Harnett County

Permit Number: **BCOM2603-0006**

Description: **Hispanic Snack Convention Bar**

Site Address: **161 S MCKINLEY ST**

LA COSECHA SNACKS
 161 S McKinley Street, Coats, NC 27521

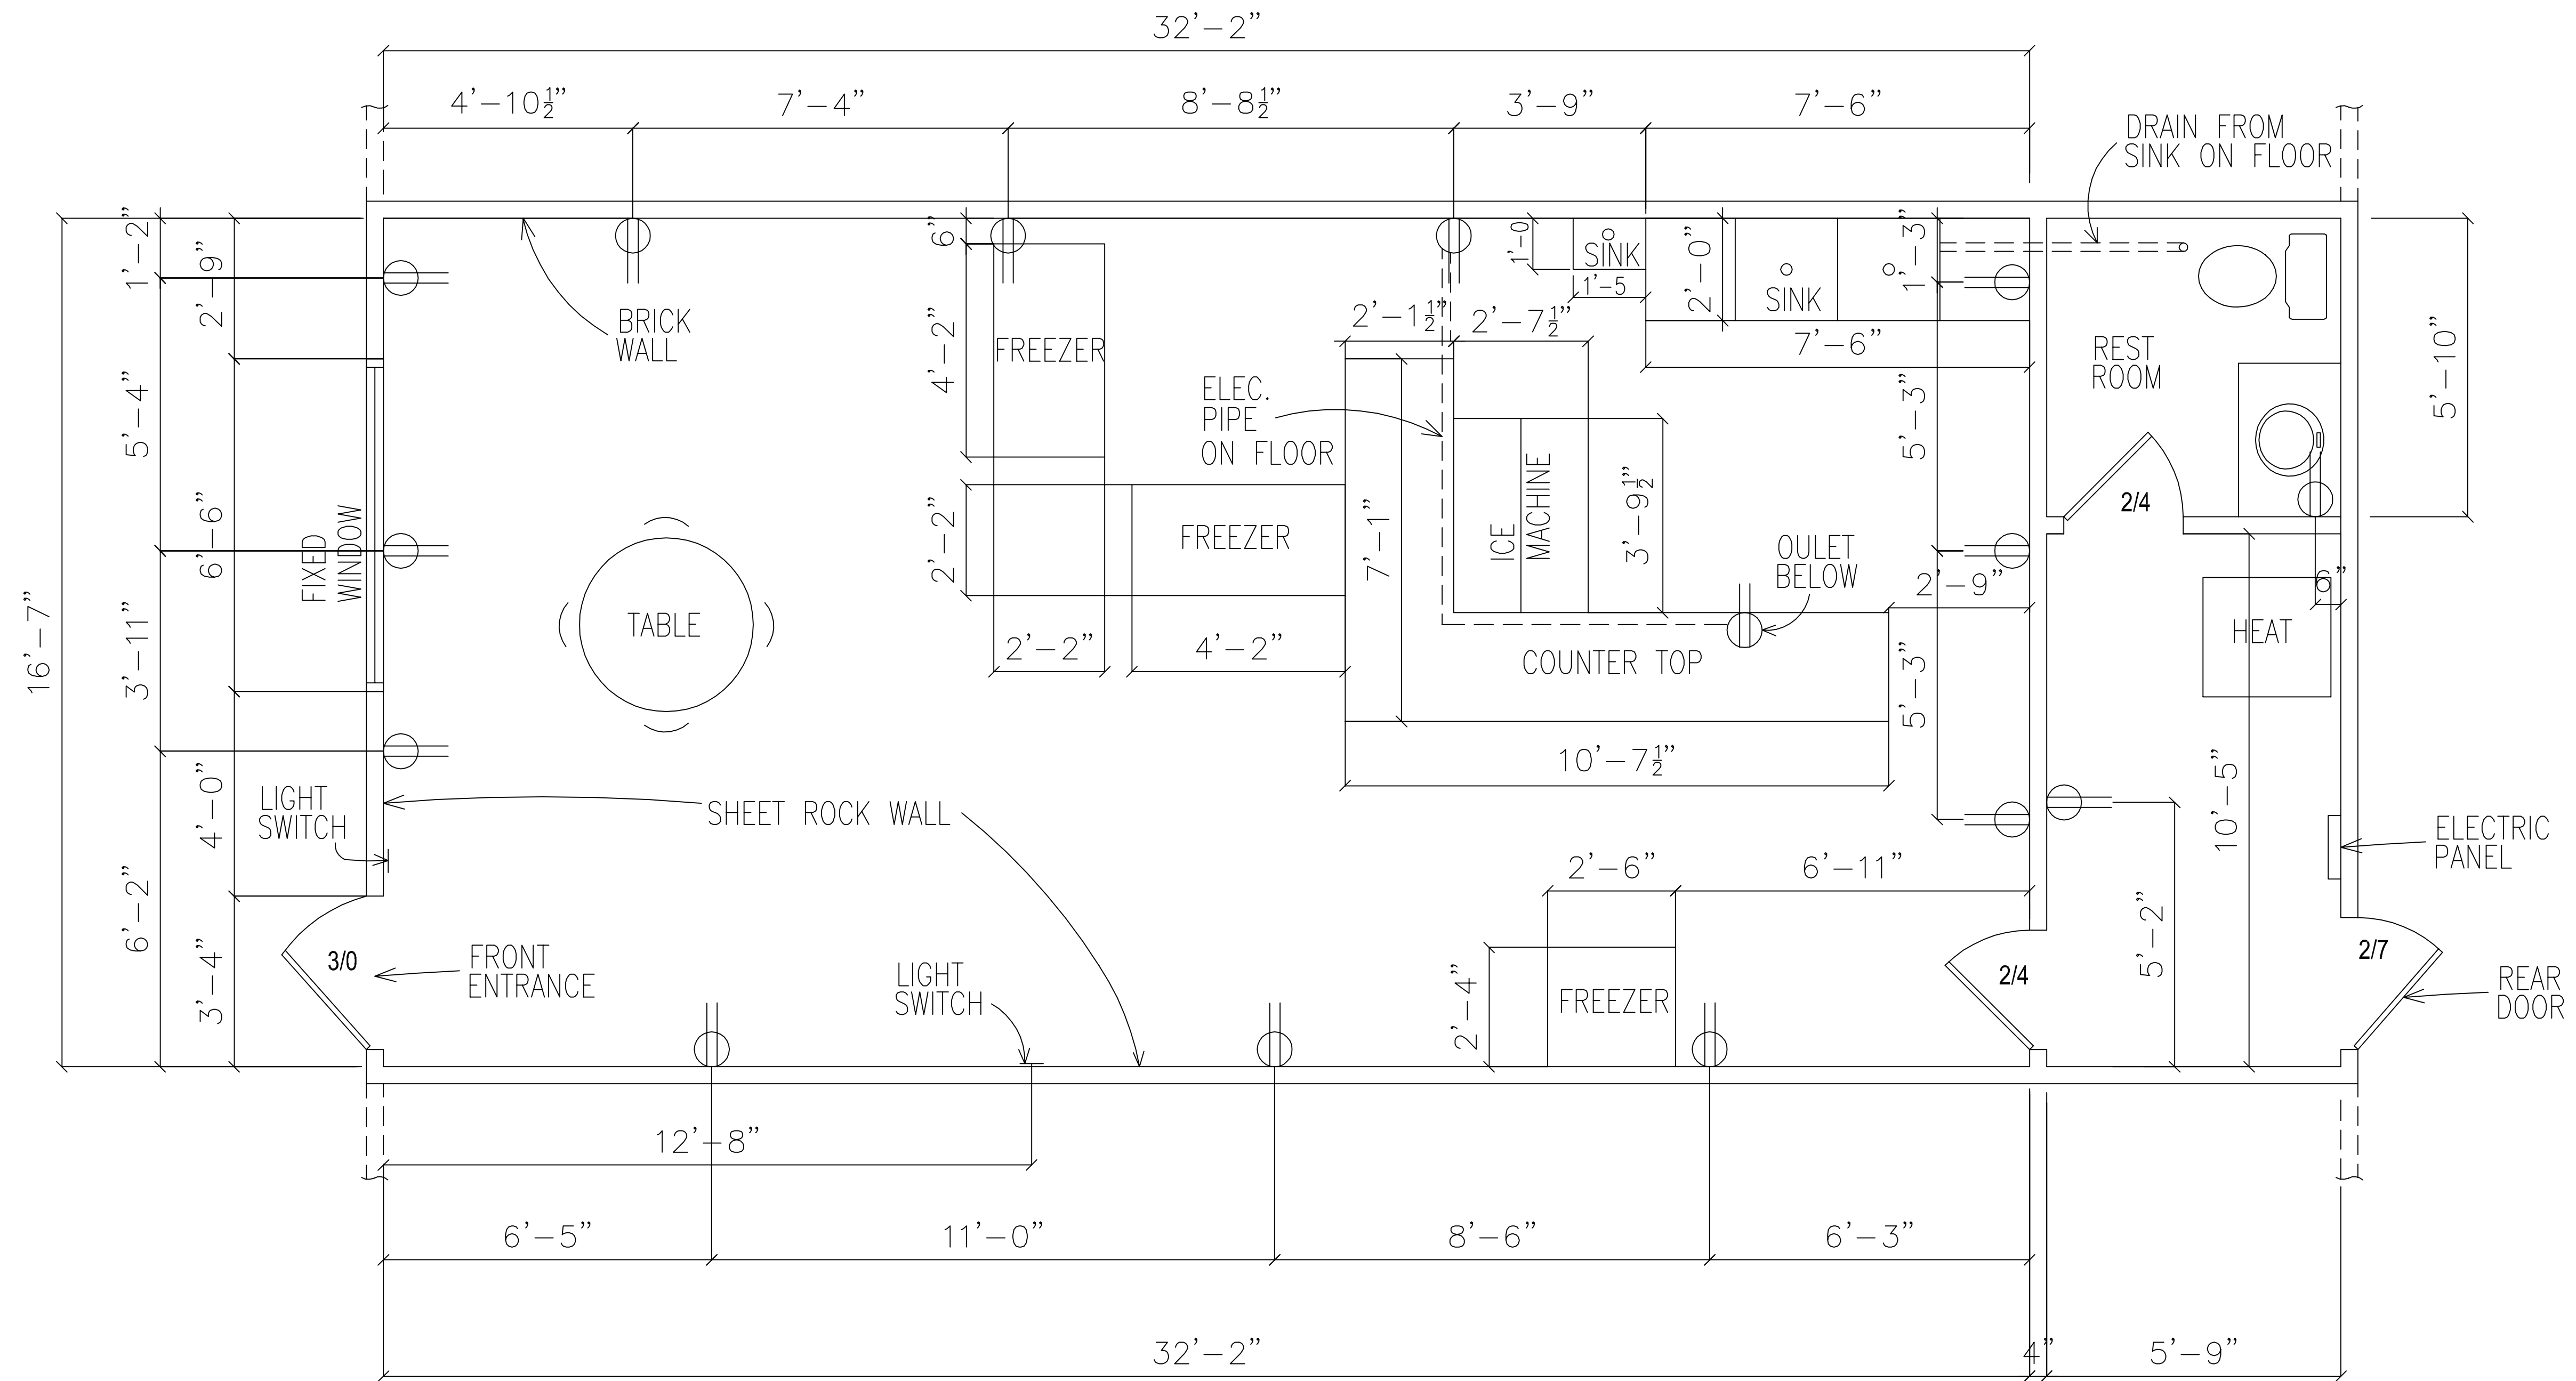
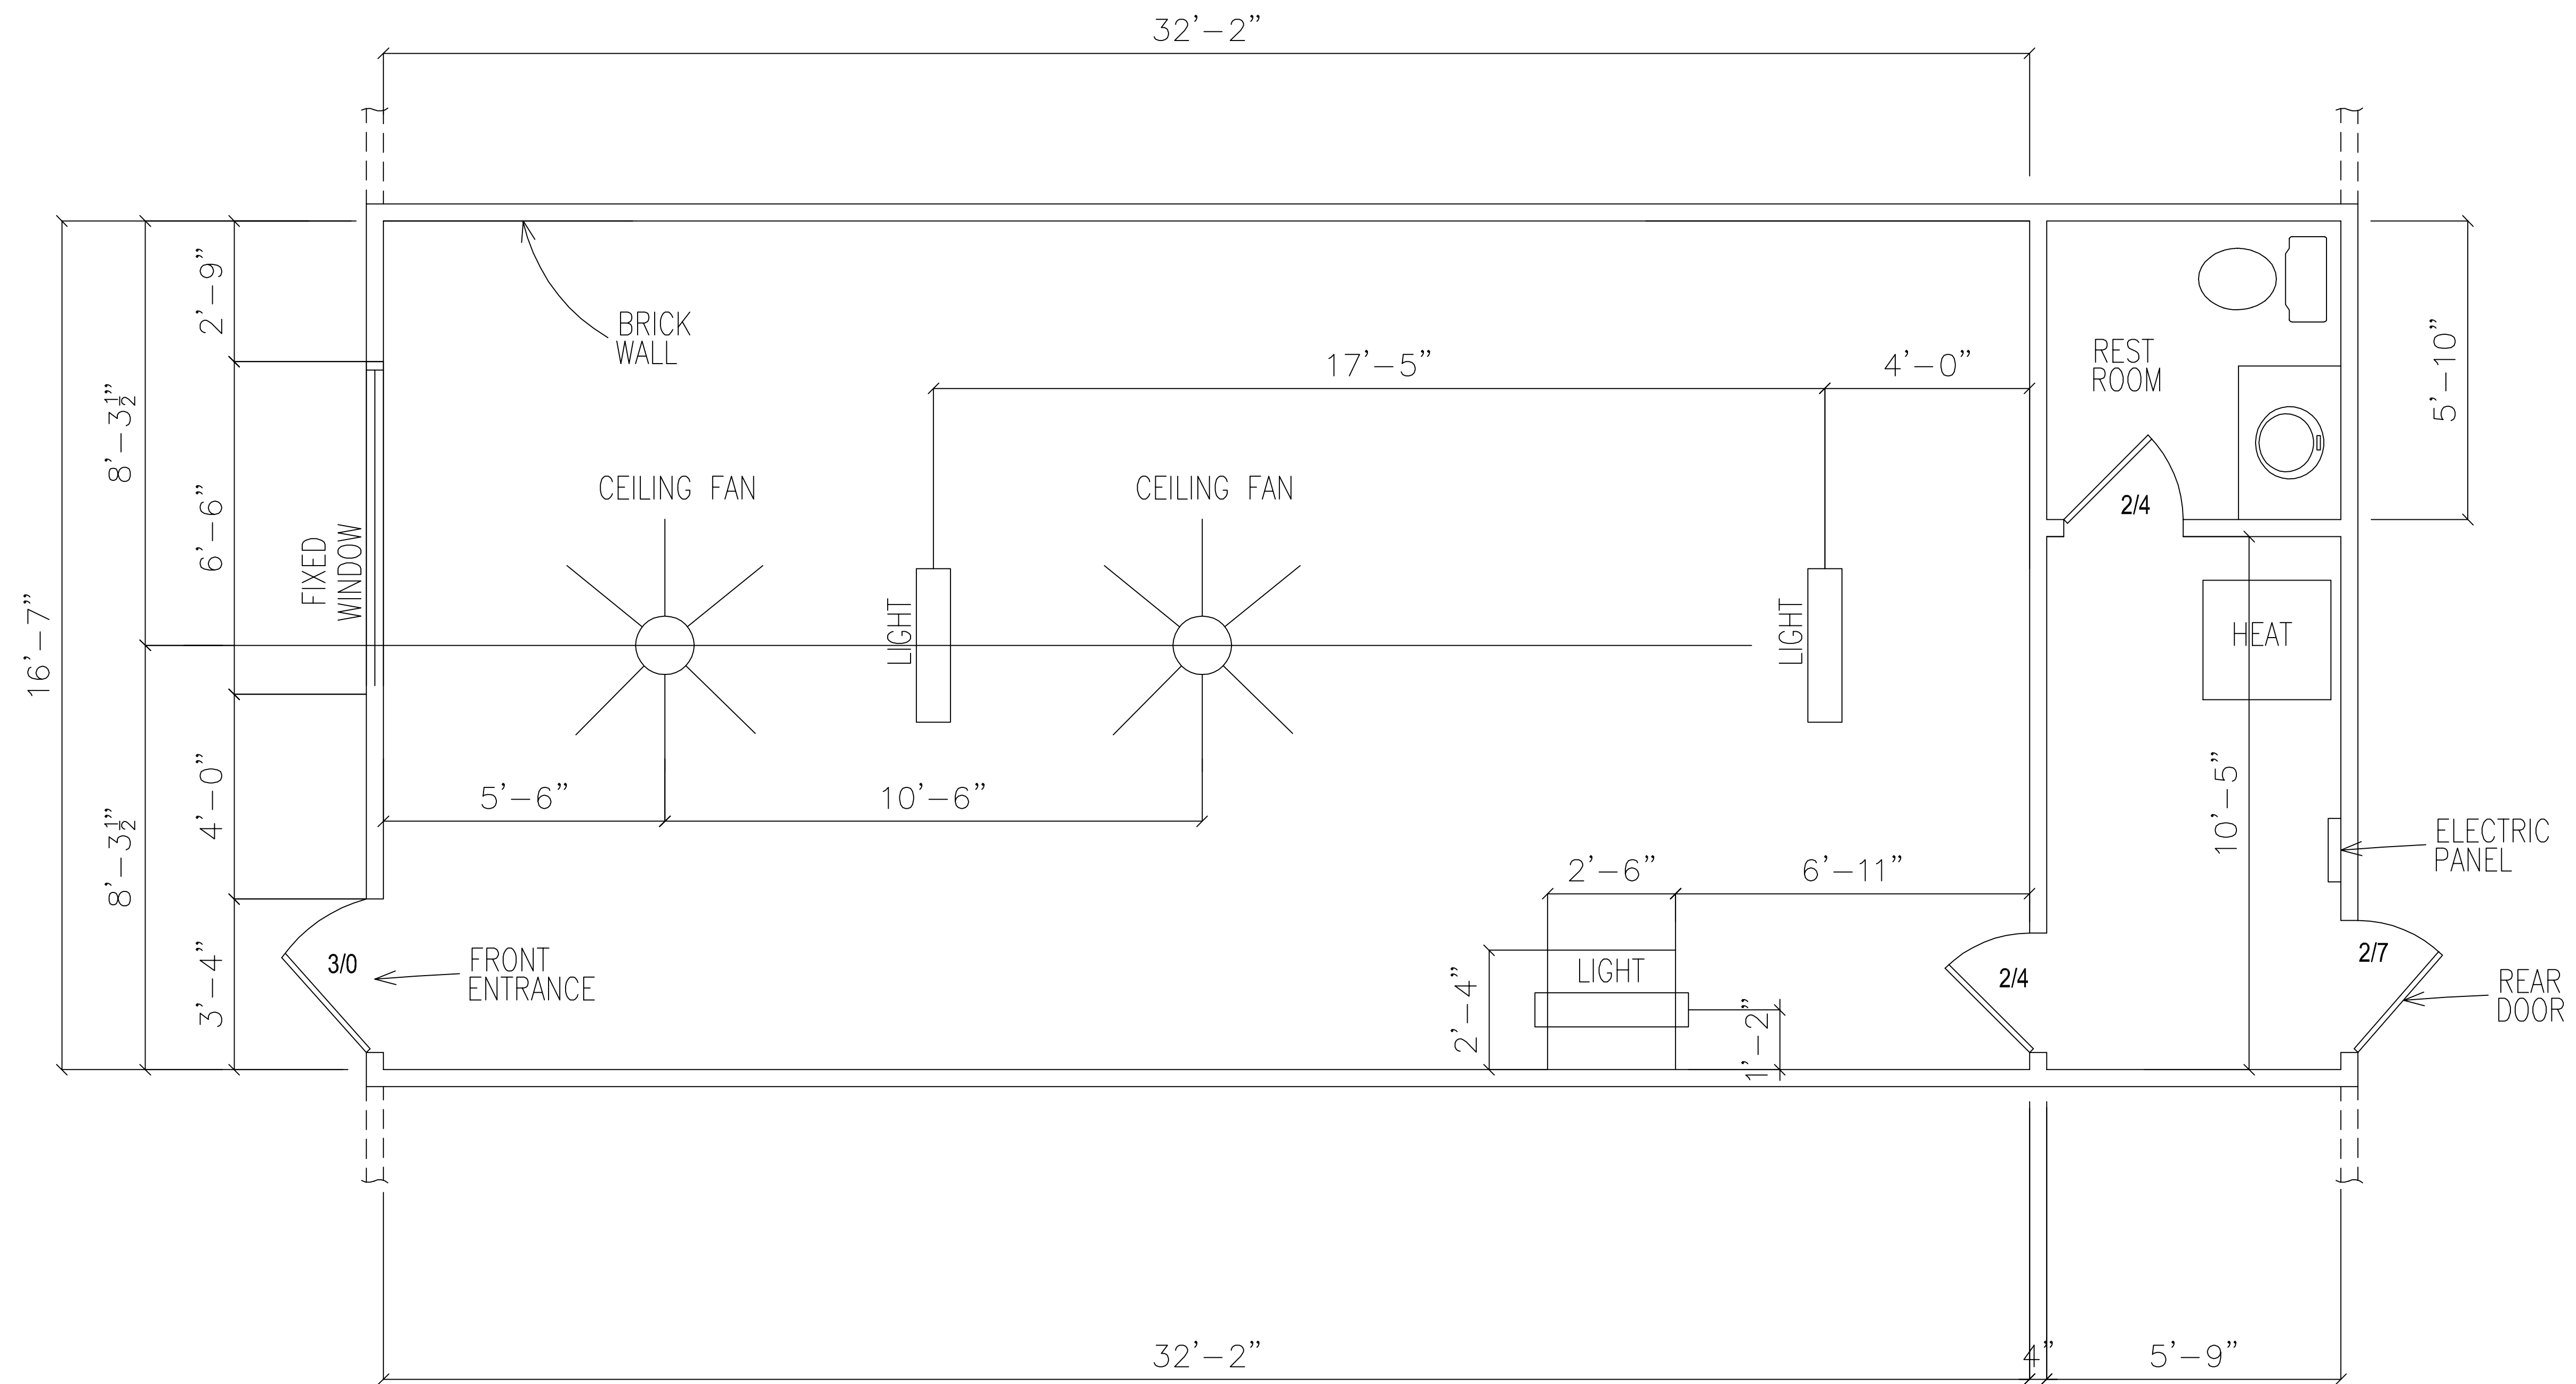
- Life safety plan, fire extinguishers, emergency and exit lighting.
- Cooking hood plans if any cooking or frying will be done.

4/7/2026	4/15/2026	4/21/2026	FIRE MARSHAL	Fire Bucket	APPROVED	See attached letter
<p>Notes:</p> <p>-Customer confirmed that exit signs & lighting are above exits on new life safety plan/site plan. Fire extinguisher is shown on new plan.</p> <p>-No cooking or frying will take place; fruit will be cleaned & cut up.</p> <p>See attached letter.</p>						
4/15/2026	4/15/2026	4/15/2026	HEALTH AND SANITATION	Cynthia Pierce	DISAPPROVED	
<p>Notes:</p> <p>Application incomplete, site plan not adequate or drawn to scale, need equipment spec sheets, need food process sheets. Emailed sent to applicant requesting information, application sent back via email.</p>						
Review Group: AUTO						
3/25/2026	4/7/2026		COMMERCIAL INTAKE	CP Bucket	APPROVED	
<p>Notes:</p>						
3/25/2026	4/1/2026	4/9/2026	COMMERCIAL BUILDING REVIEW	Brad Sutton	DISAPPROVED	
<p>Notes:</p> <p>Need a scaled plan</p> <p>Need food details. Cooking? Prepackaged? If cooking, provide hood and cooking equipment details</p>

3. 3-Compartment Sink:
 - a. Brand – Serv-Ware
 - b. Model # - E3CWP18182-18

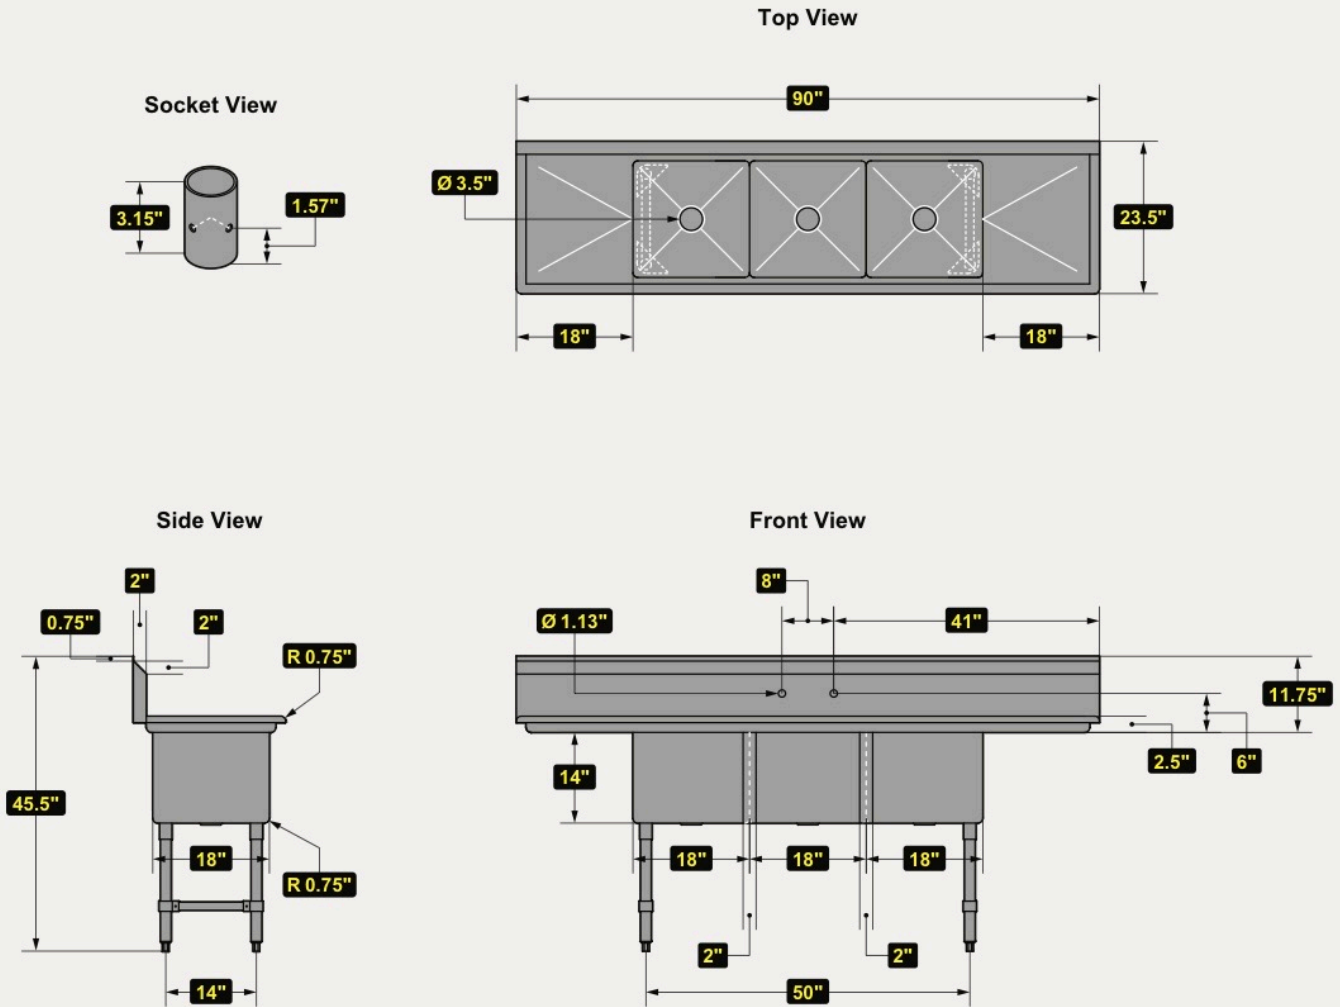
1. You install a minimum of a 50 GPM poly grease trap on the 3-compartment sink. All compartments will be plumbed to the trap. If additional kitchen or prep sinks are installed, you will be required to install additional traps.
